WEST SUSSEX COUNTY COUNCIL CONSULTATION

TO:	Arun District Council FAO: Hannah Barker
FROM:	WSCC - Highways Authority
DATE:	30 November 2021
LOCATION:	22 Osprey Gardens Bersted PO22 9QG
SUBJECT:	BE/163/21/PL Erection of 1 No. dwelling. This site is in CIL Zone 4 and is CIL Liable as a new dwelling.
DATE OF SITE VISIT:	n/a
RECOMMENDATION:	Advice
S106 CONTRIBUTION TOTAL:	n/a

Ground floor plan
1 : 50

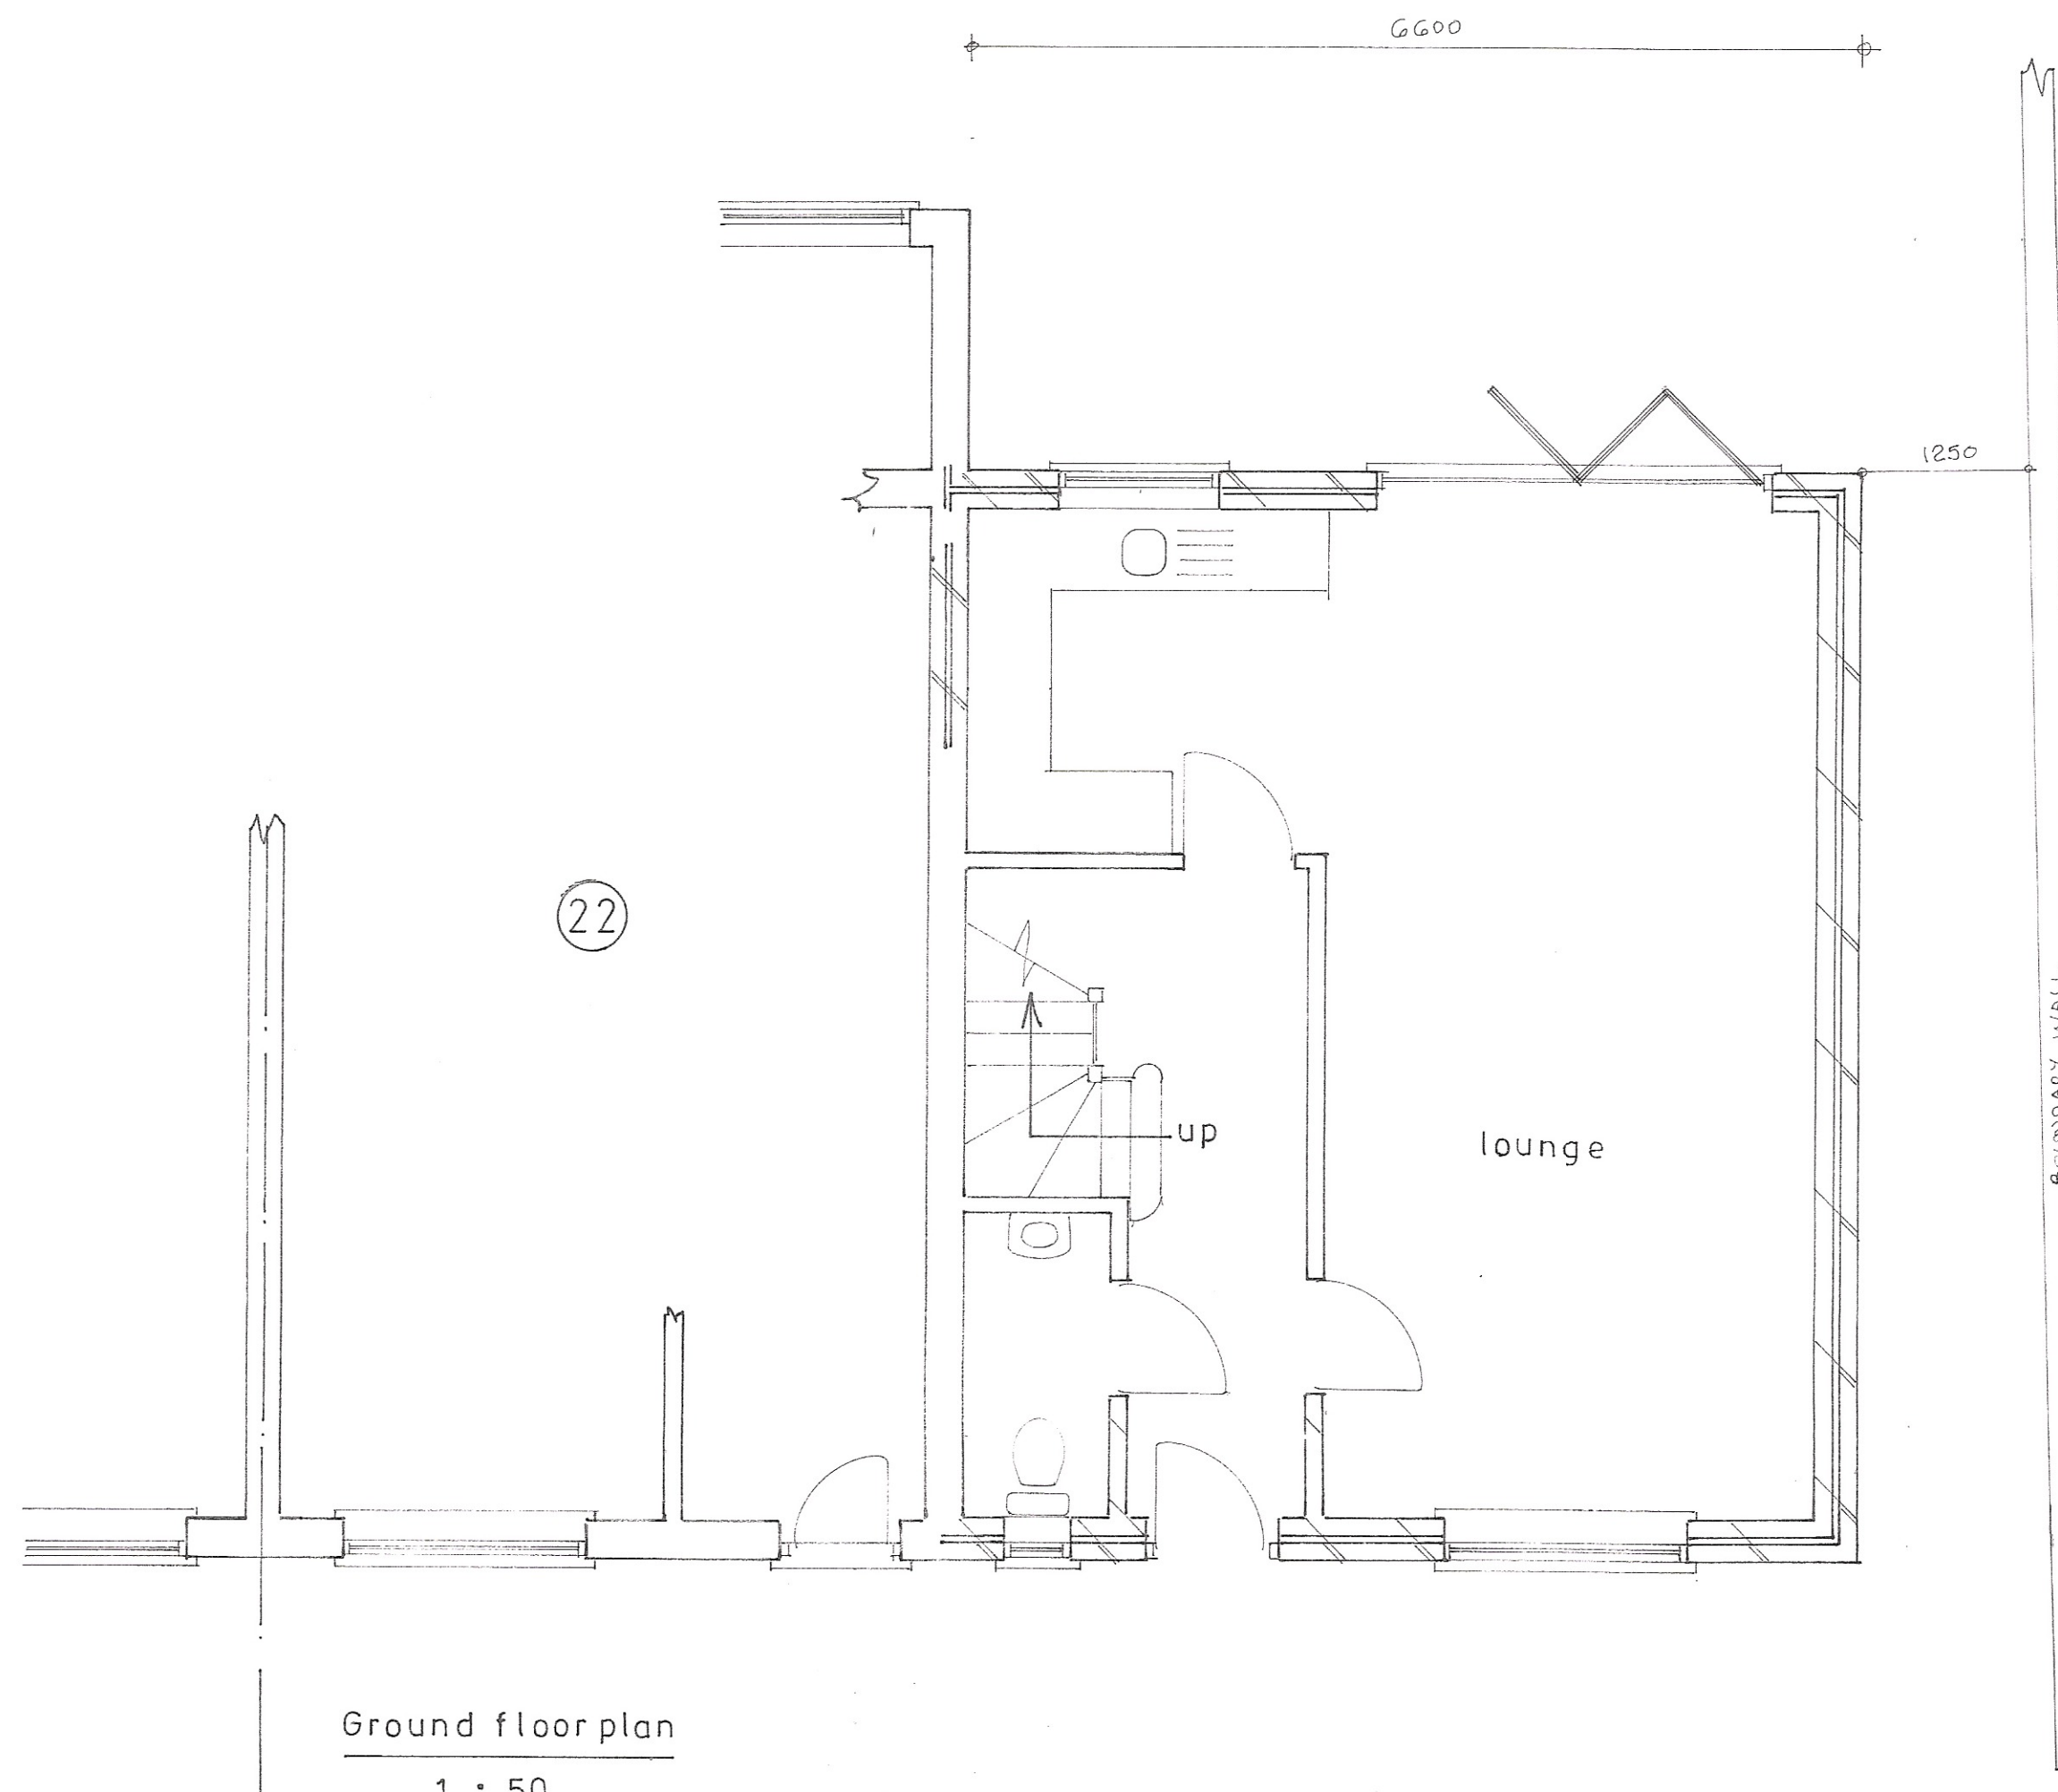
The plans demonstrate that 1 parking space currently exists on the site frontage. The proposed plans indicate that this parking space will be retained and utilised by the proposed dwelling and an additional parking space will be provided to the site frontage of the host dwelling. The plans do not clearly demonstrate the size of the parking spaces however details of this can be secured by condition. The applicant should be aware that their parking space should meet minimum specifications of 2.4 x 4.8m. If the parking space is in front of a means of escape for example a front door the parking space should have a minimum depth of 6m.

The proposed plans do not demonstrate whether the existing garage is to be demolished or retained. The plans also do not demonstrate secure and covered cycle storage for the proposed dwelling. If the garage is to be retained this could be utilised for cycle storage however clarification of whether the garage will be allocated to the proposed dwelling would be sought. Details of cycle storage can be secured via condition.

No part of the development shall be first occupied until the car parking spaces have been constructed in accordance with plans and details to be submitted to and approved in writing by the Local Planning Authority. These spaces shall thereafter be retained at all times for their designated purpose.

No part of the development shall be first occupied until covered and secure cycle parking spaces have been provided in accordance with plans and details to be submitted to and approved by the Local Planning Authority.

existing block plan

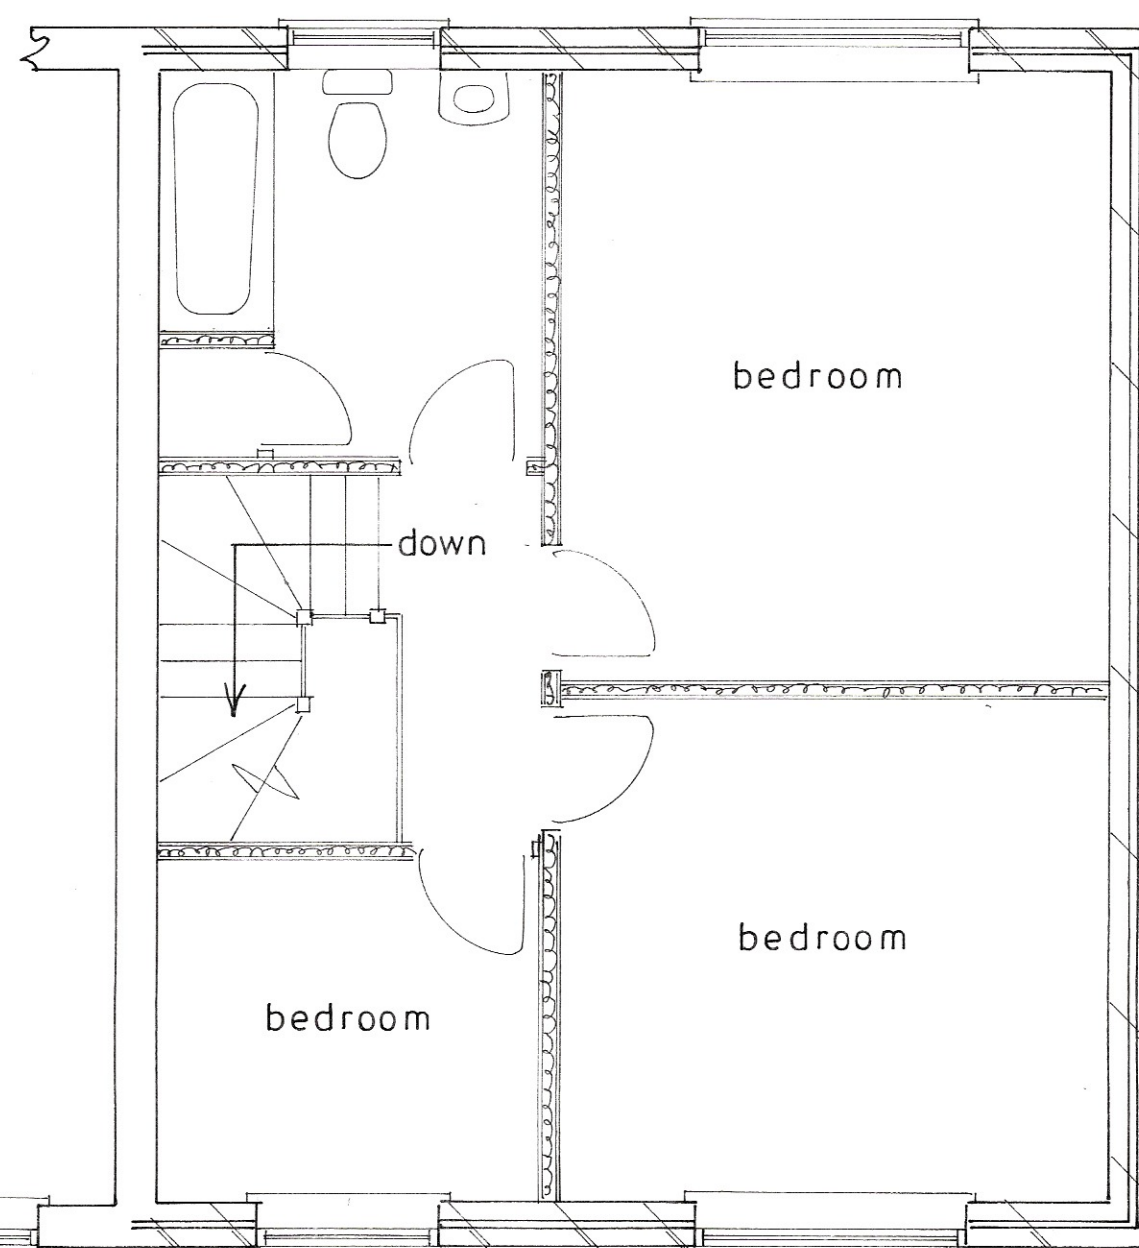
The proposed plan demonstrate that the existing dropped curb to the site will be widened to provide a parking space for both the existing and proposed dwelling. No details of the proposed access width have been provided however this can be secured by condition. The applicant should be aware that any access works would be subject to a licence from the WSCC area engineer and must be constructed to a specification agreed with them.

No part of the development shall be first occupied until such time as the vehicular access has been constructed in accordance with plans and details to be submitted to and approved in writing by the Local Planning Authority.
